Appendix C

Agency	Issues Raised	Comment
Liverpool City Council	All construction traffic should use the proposed northern access road when it is completed.	The northern access road is not part of the proposal. This issue will be considered in the assessment of project application for MP 08_0062 for Infrastructure and Ancillary Hospital Works.
	Construction traffic should not use certain roads between 8:30am and 9:30am and 2:30pm and 3:30 pm on school days, due to school and pedestrian traffic.	Addressed in PPR and assessment report. The Department supports the proponent's view that the restrictions will delay construction times and budgets, although changes to the start and finish times have been recommended to minimise amenity impacts. A condition has also been recommended for additional consultation with local schools.
	An area should be provided for car parking for construction workers.	Addressed in the PPR and assessment report. Insufficient are for on site parking,

Fig 2.05 - Flooding
Liverpool Hospital Redevelopment - Stage 2 Infrastructure and Ancillary Hospital Works (MP08_0062)
October 2008

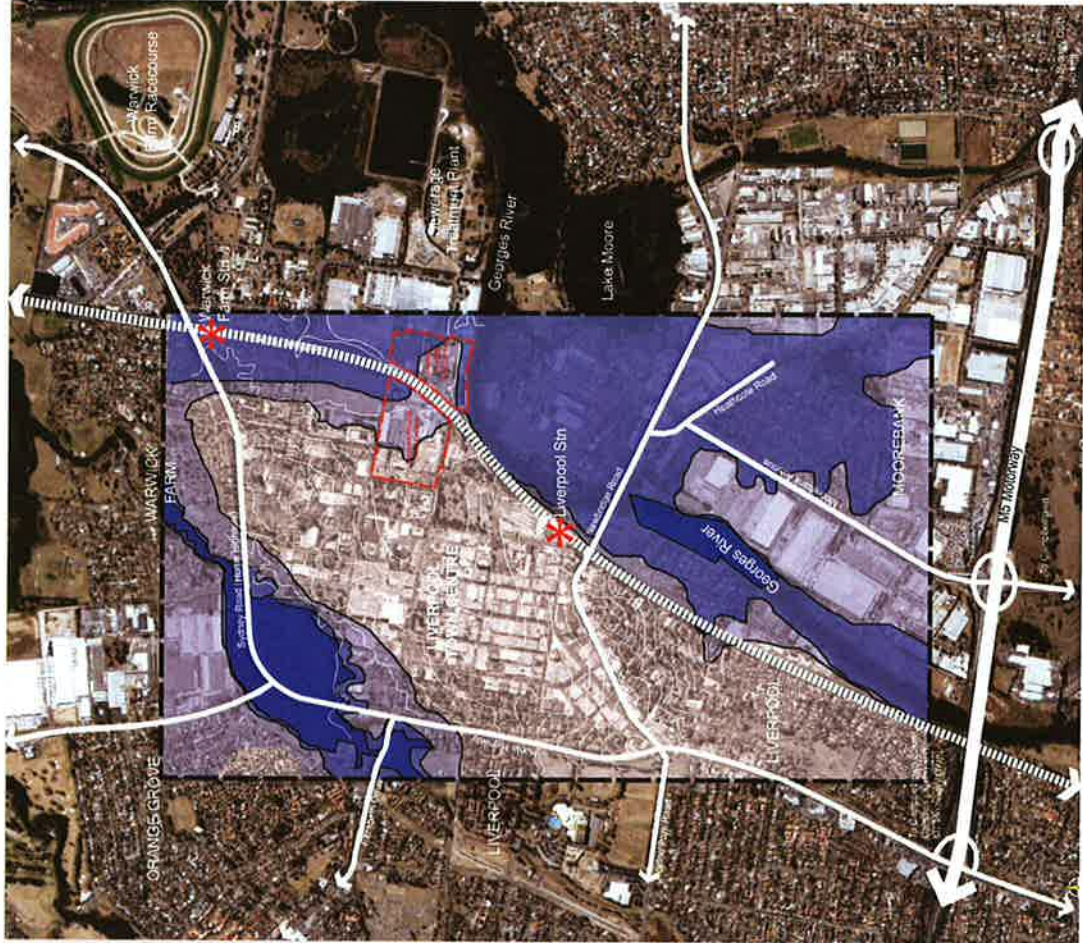
Flood management measures should be put in place for parts of the development below the PMF flood level	Addressed in EA, PPR and assessment report. Measures have been put in place including bunding. Considered satisfactory.
	Disposal of waste, including hazardous waste.	Addressed by PPR, Statement of Commitments and recommended condition of approval.
Sydney Water	Sydney Water should be involved in consultation for diversion of stormwater drainage connecting to Sydney Water's stormwater system(along with Council).	Condition recommended
	Trade waste requirements to be met.	Advisory condition included
	New stormwater connections needed, along with developer charges.	Advisory condition included
	Extension of childcare centre not supported due to buffer zone of Sewerage Treatment Plant.	Child care centre expansion not part of the current application.
Ministry of Transport	Insufficient assessment of implications for public transport. A workplace travel plan should be prepared .	Traffic and transport addressed in the Concept Plan, current application consistent with the approved Concept Plan.
